# **East Anglia ONE North and East Anglia TWO Offshore Windfarms**

## **Applicants' Responses to Examining Authority's Written Questions 2**

### **Volume 5 – 2.8 Historic Environment**

Applicants: East Anglia ONE North Limited and East Anglia TWO Limited  
Document Reference: ExA.WQ-2.D6.V1\_05  
SPR Reference: EA1N\_EA2-DWF-ENV-REP-IBR-001239\_05 Rev 01

Figure: 6g
CHVP1: PROW south of Friston Church

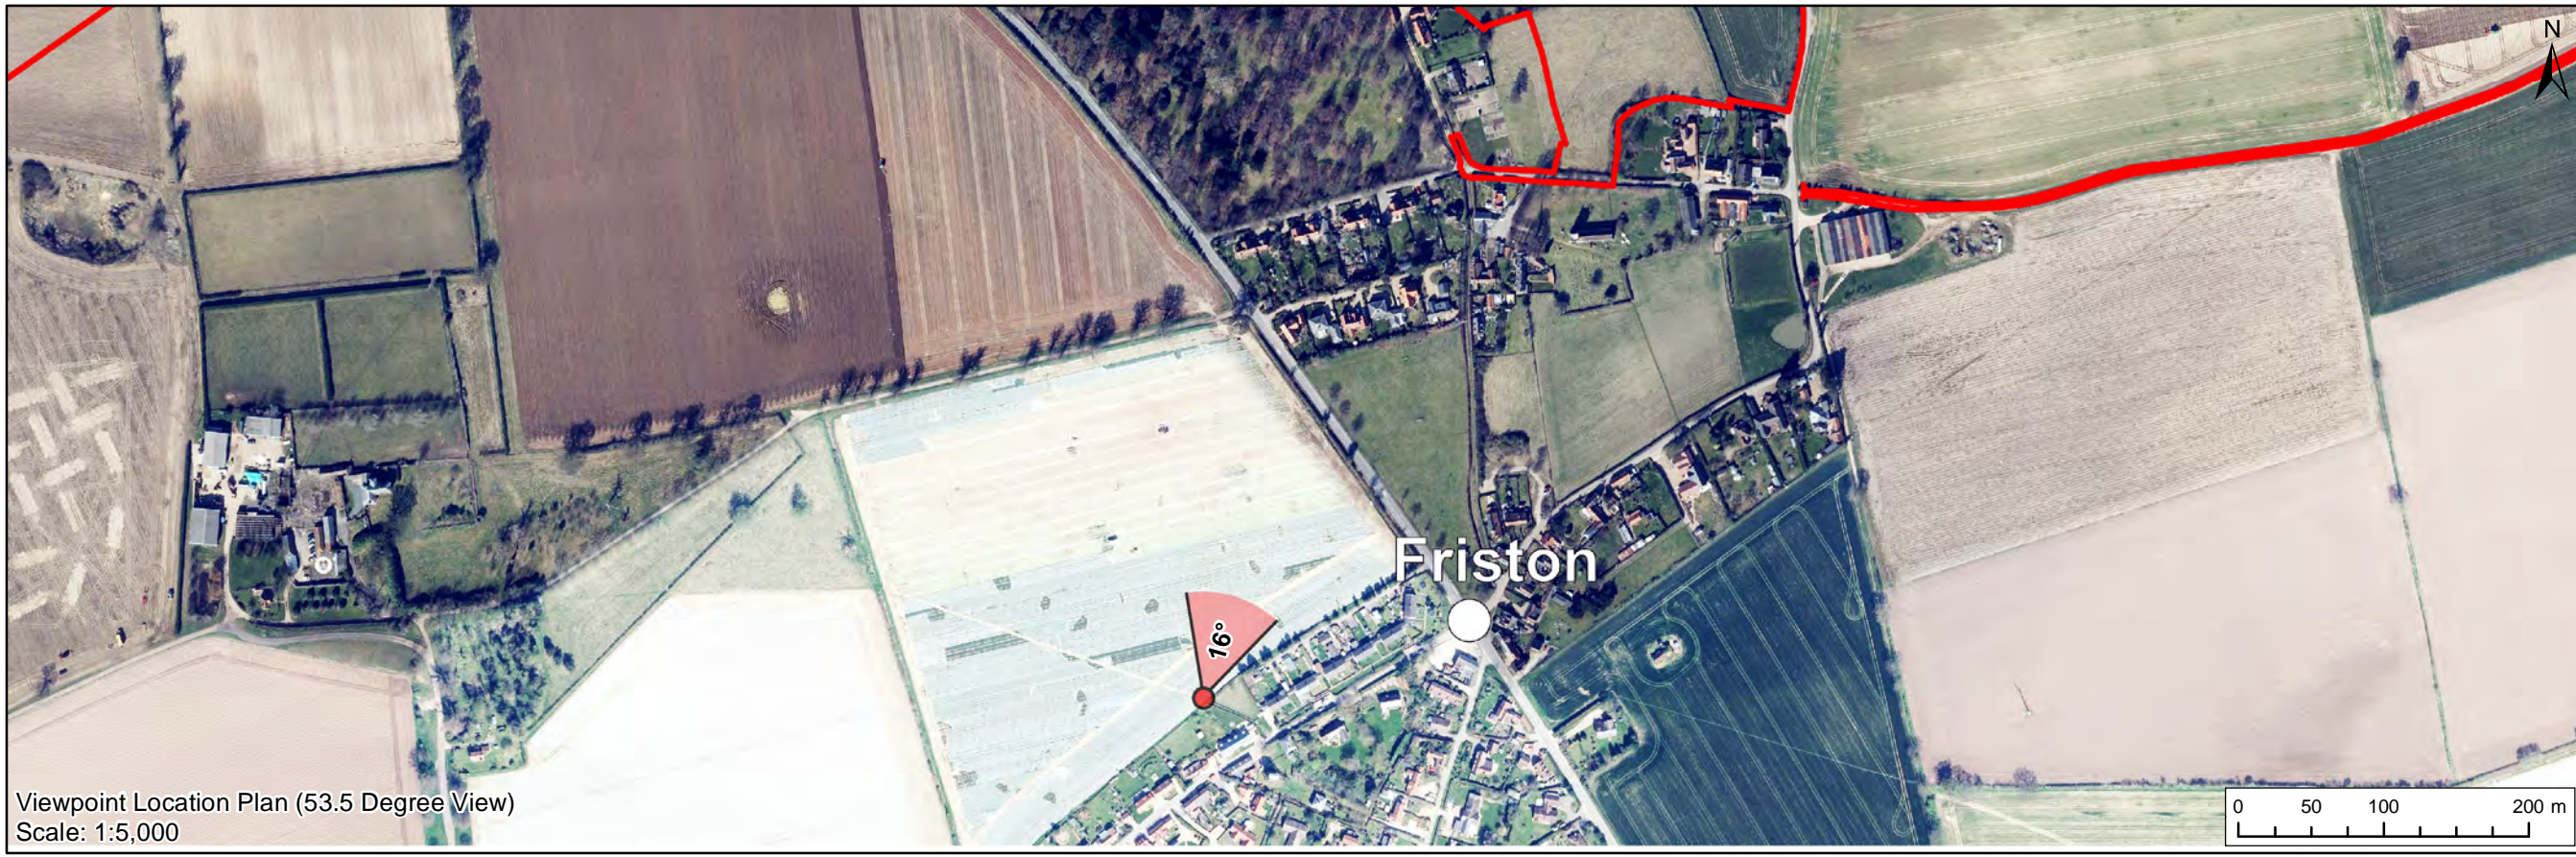
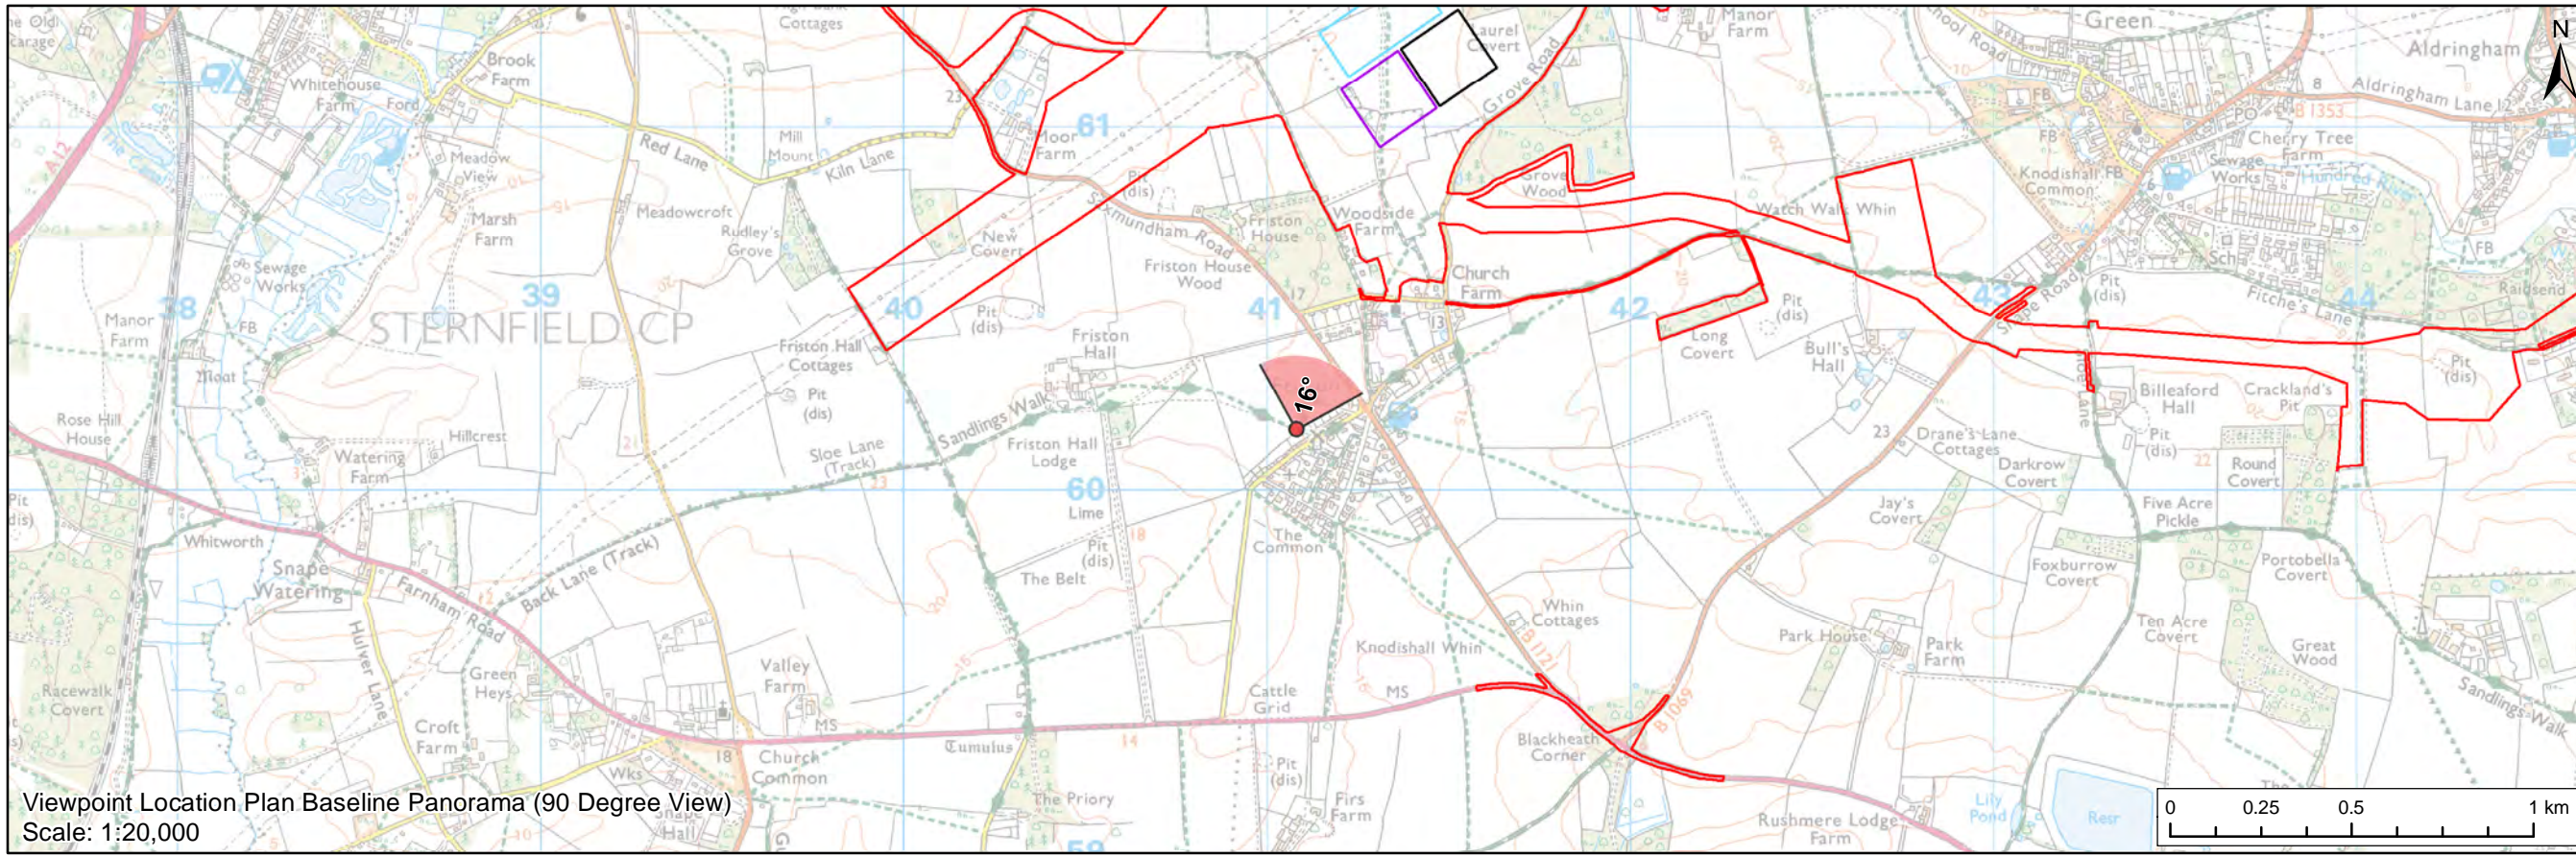
2.8.6	Applicants		<p><b>Church of St Mary</b></p> <p>At the ExA's site visits [EV-007d] the tranquillity of the Church and its graveyard was noted, including the War Memorial. An inspection inside the Church allowed items detailed in the building's listing to be appreciated and it could be seen that views over the fields to the north could be made not only from various points within the grounds of the Church, but also from the northern windows in the Church's nave.</p> <p>Make any further comments you wish to make concerning any effects of the proposals on the significance of the relevant heritage assets, including on both during operation and construction of the proposals.</p>	<p>The Applicant agrees that the church and its graveyard are tranquil places and this quality supports the experience and appreciation of the church and war memorial as places for reflection and quiet contemplation both now and in the past. However, the spatial separation of the substations from the church means that, once operational, it will remain a tranquil place. This reflects the limited visibility of the substations in views looking north from the graveyard and the absence of intrusive noise from the substations.</p> <p>Similarly, the appreciation of features of historic and architectural interest within the church will not be diminished by the fact that a visitor in the church might have a partial view towards the substations if they were to look out of one of the north-facing windows. Again, the spatial separation and limited visual change will ensure that the church and its historic character will continue to dominate the experience. The Applicants will continue to revise the OLMS in consultation</p>

ExA. Question Ref.	Question addressed to	ExA. Question	Applicants' Response
			<p>with interested parties to further reduce the level of change in the setting of the church.</p> <p>In considering the predicted impact of the proposals on the significance of the church it is essential that any evidence for change in the setting is considered in the context of how setting contributes to the significance of the asset 'in the round'. Therefore, whilst we recognise that elements of the substations would be more or less visible in views north from the churchyard (depending on the precise viewpoint chosen), there are many other valued views both out from and towards the church that would be entirely unchanged.</p> <p>The analysis provided by the applicants [APP-519/520 and REP4-006] aims to provide a balanced summary of all relevant aspects of the setting, not simply those areas where change is predicted. It is also important to note that the viewpoints selected for illustration inevitably focus on aspects of the setting where change would or might occur. A balanced understanding of how the setting would change can therefore only be gained from a site visit with copies of the visualisations to hand.</p> <p>All of the comments above relate to the operation of the substations and it is accepted that the construction phase would include works closer to the church. These would include excavation of the cable trenches between the church and Grove Wood, sub-surface drainage works extending south from the substations and landscape mitigation planting in the fields to the north of the church. All of these activities would generate some degree of temporary noise and visual disruption in the setting of the church. However, as justified in</p>

ExA. Question Ref.	Question addressed to		ExA. Question	Applicants' Response
				<p>the original heritage assessment (ES Appendix 24.7, APP-519), any adverse impact on significance would be short-lived and entirely reversed at the end of construction works, and therefore does not merit detailed consideration.</p> <p>The Applicant remains confident that it is only the permanent changes in the setting of this and other heritage assets due to the operation of the substations that has potential to cause significant adverse effects.</p>

Figure: 8g
CHVP3: PROW between Moor Farm and Little Moor Farm

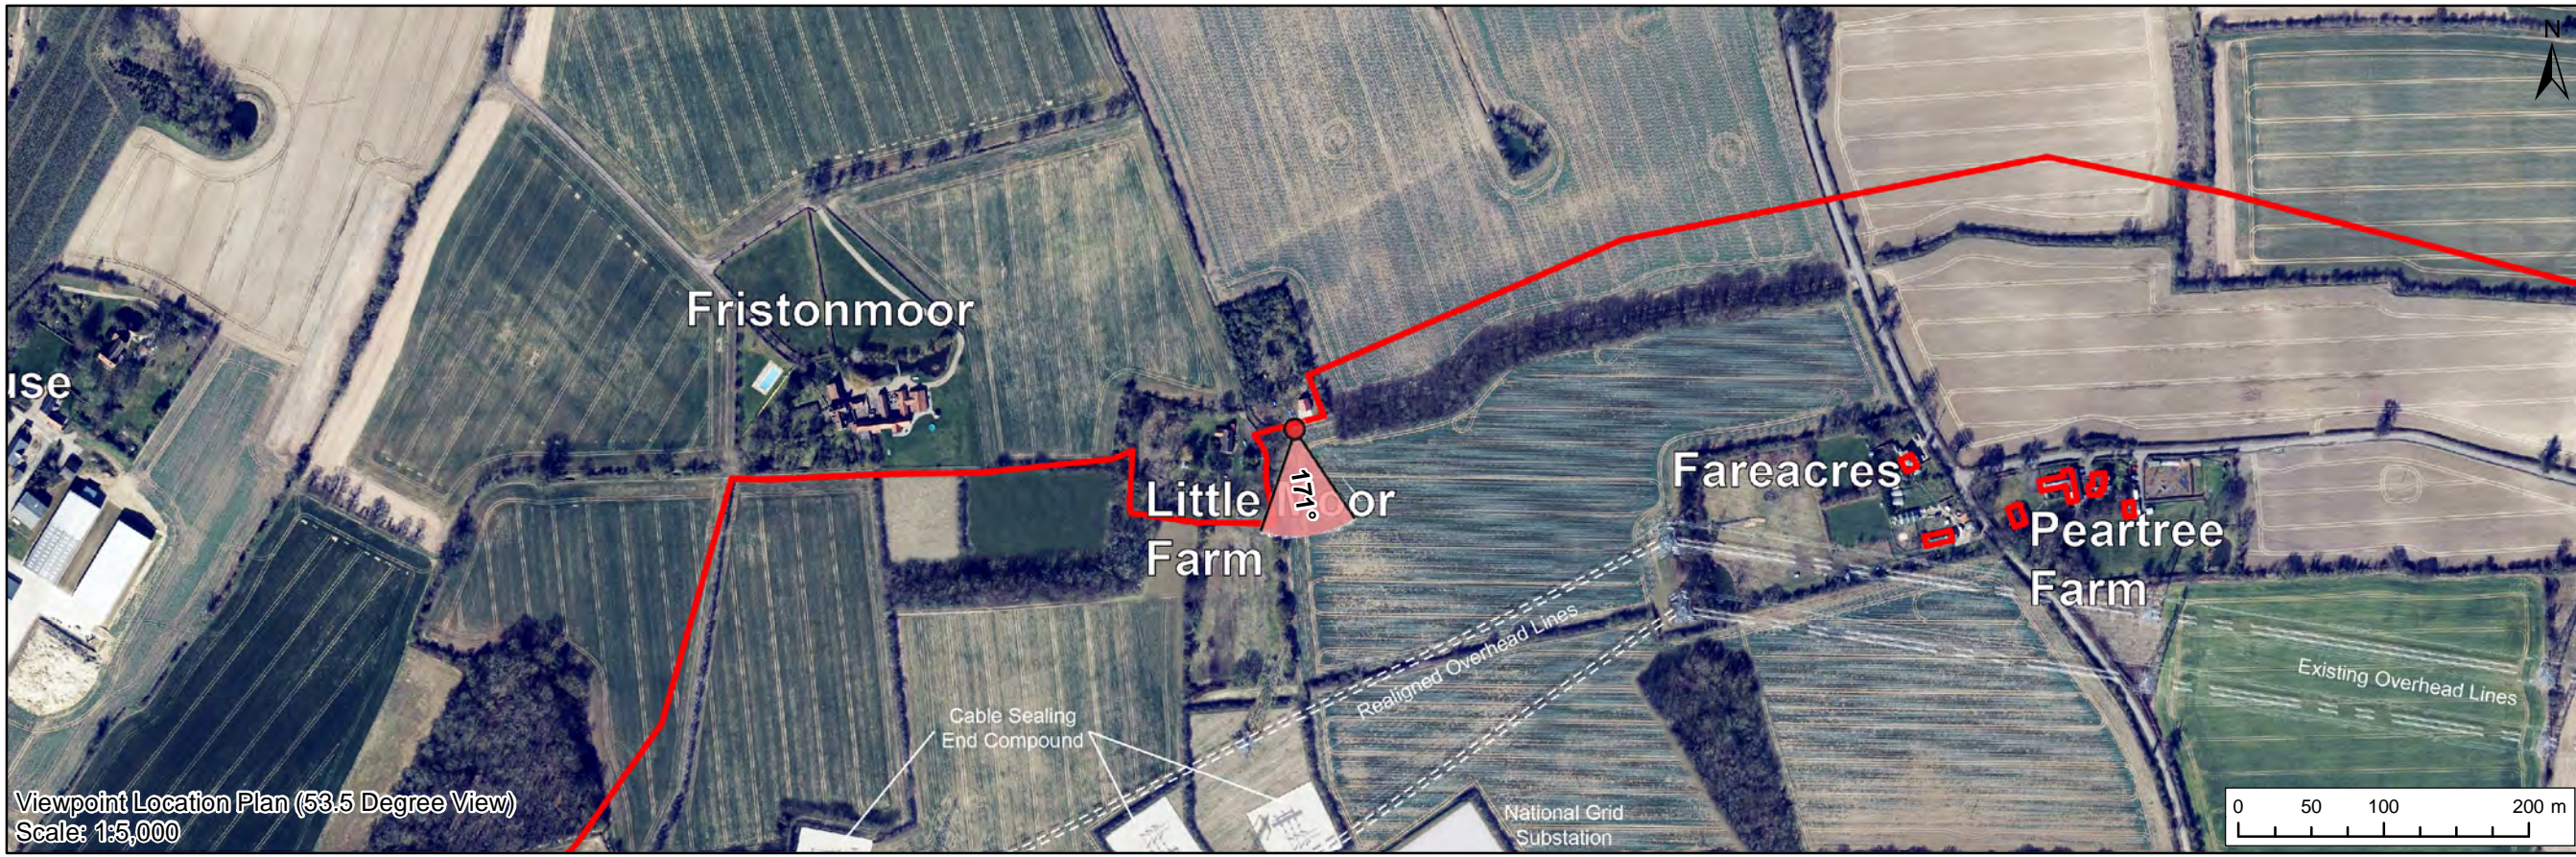
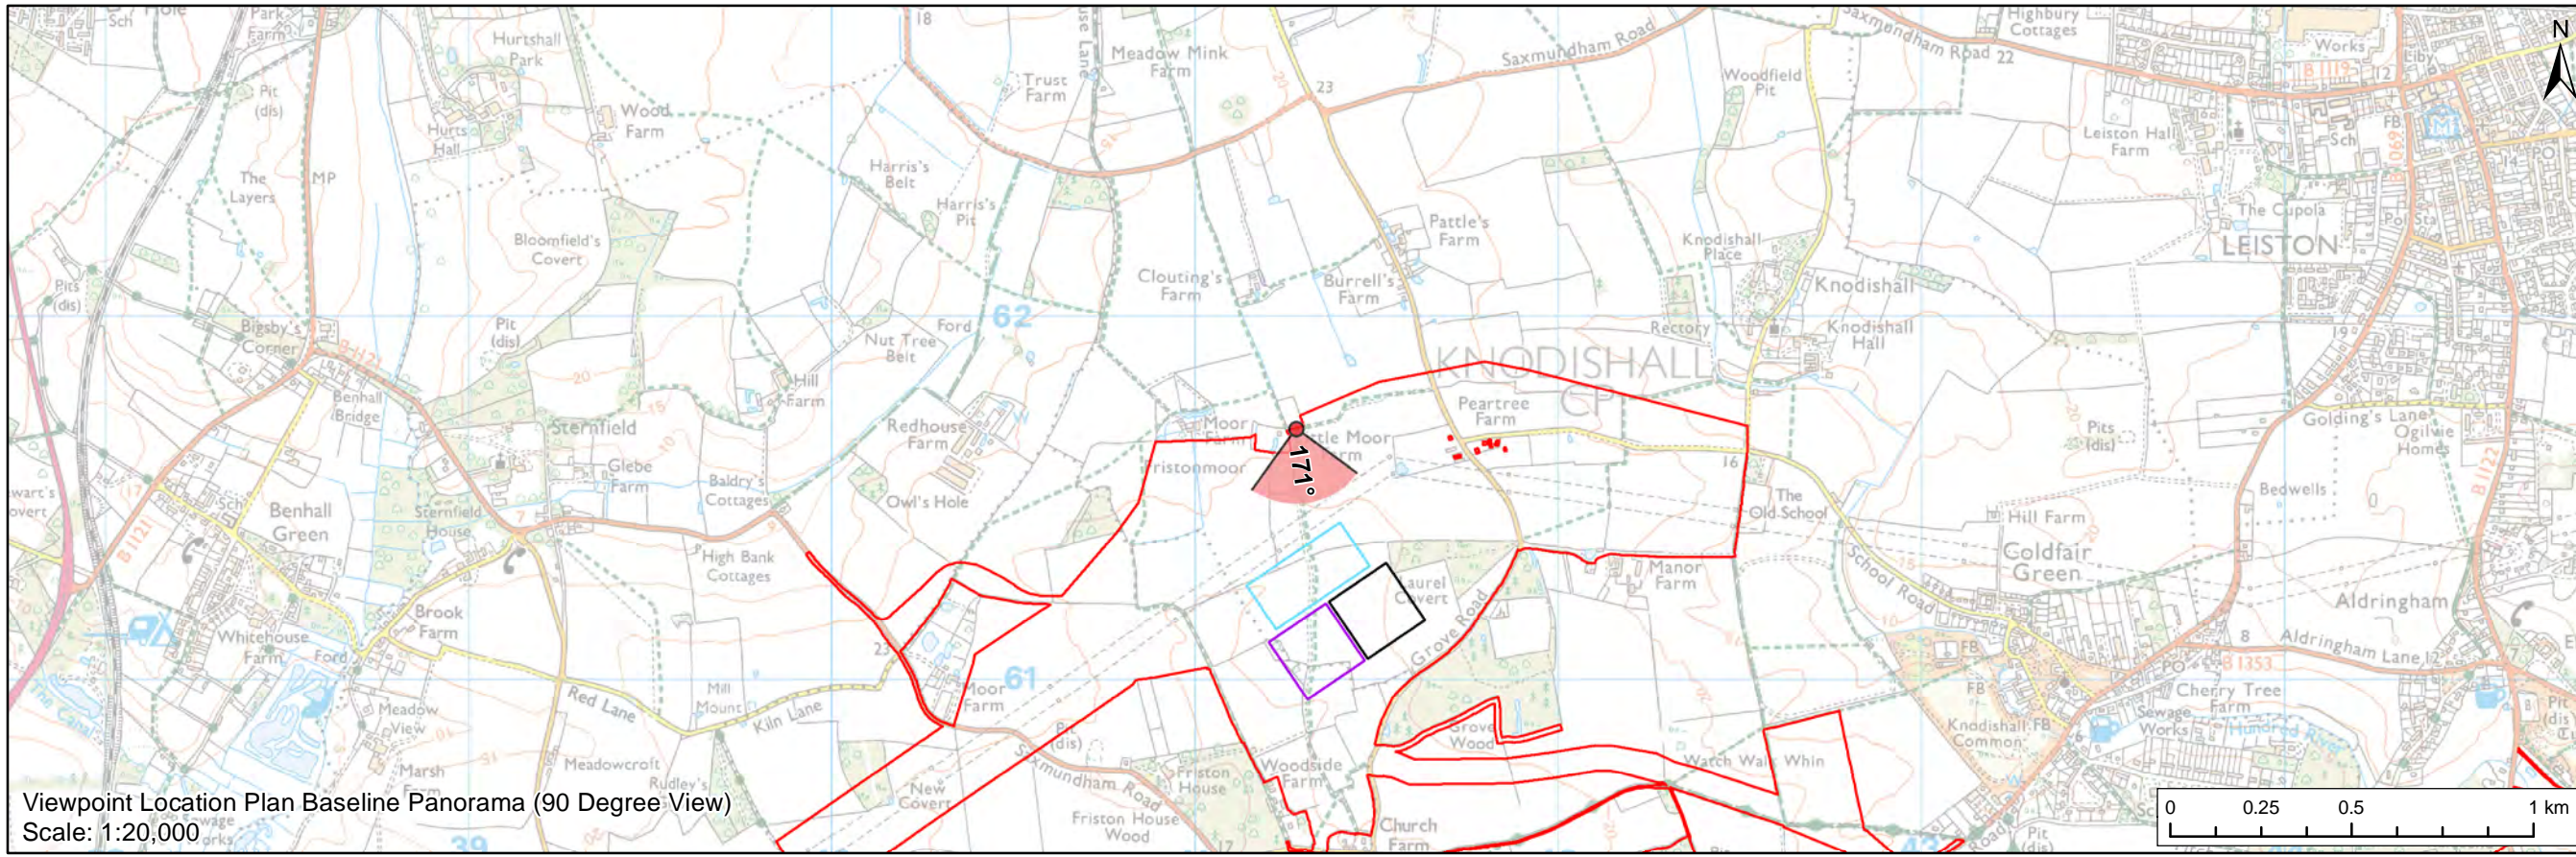
2.8.5	Applicants	<p><b>Little Moor Farm</b></p> <p>The Heritage Assessment Addendum [REP4-006] considers that the revised OLMP and an included woodland belt, as well as reduced finished ground levels and heights of structures would reduce previous assessments of effect on the significance of the heritage asset, with low magnitude for all three operational arrangements, is equivalent to less than substantial harm and an effect of minor significance in EIA terms.</p> <p>However, CHVP4 [REP4-009] continues to show a large section of the proposed National Grid substation still to be visible, even after 15 years of operations, with the previous largely open view of the Church at Friston completely removed by the proposals.</p> <p>Further justify your view for the reduction in proposed effect on the significance of the heritage asset.</p>	<p>CHVP4 is a location on the Public Right of Way (PRoW) immediately to the east of Little Moor Farm and is one of two viewpoints that have been used to illustrate how the projects would affect the setting of this Listed Building. The other viewpoint is CHVP3 [REP4-008], on the PRoW between Little Moor Farm and High House Farm.</p> <p>As noted by the ExA, the revised Outline Landscape Management Plan (OLMP) includes an additional belt of trees to the south of CHVP4 that is predicted, following fifteen years of growth, to largely screen the substations in this view. The predicted level of screening at CHVP4 may be appreciated by comparing the photomontages showing all three substations without screening (Figure 9g) and with screening (Figure 9h). Only a short section of the national grid substation and the gantry for the eastern sealing end compound remain visible in Figure 9h.</p> <p>The adverse impact that the projects would have on the significance of Little Moor Farm is due largely to the change in landscape character that the substations would cause. The current landscape setting of Little Moor Farm is rural and agricultural, supporting our appreciation of this 17<sup>th</sup> century farmhouse in an appropriate, albeit not original landscape setting.</p>

ExA. Question Ref.	Question addressed to	ExA. Question	Applicants' Response
			<p>In the original assessments of Little Moor Farm [ES Appendix 24.7, APP-519/520] a residual adverse impact of medium magnitude primarily reflected the failure of the OLMP at that point to mitigate the dominant presence of the substations in the immediate vicinity of Little Moor Farm (as illustrated by photomontages from CHVP4). Revision of the OLMP and the addition of a tree belt to the south of CHVP4 would considerably reduce the visibility of the substations. When this measure is combined with other proposals in the OLMP. Including the tree belt south of Friston Barn and the planting along the track running east from Little Moor, the overall result is the retention of Little Moor Farm in a landscape that retains much more of a rural agricultural character.</p> <p>It is this analysis that leads to the revised conclusions regarding residual impact as summarised in Table 2 of REP4-006. The mitigation provided for in the OLMP is now considered to materially reduce the adverse effect of the substations on the landscape character of the setting of Little Moor Farm.</p> <p>The ExA also notes that the Church of St Mary Friston is currently visible in the view from CHVP4 and this view would be obstructed by the proposals. This obstruction was noted by the Applicants in the original heritage assessment [APP-519/520] where it was addressed as part of the analysis of the setting of the church. In that assessment the loss of sequential views of the church when walking south along the path to Friston (not simply the static view from CHVP4) was identified as the key change in the setting of the church that would lead to loss of significance.</p>
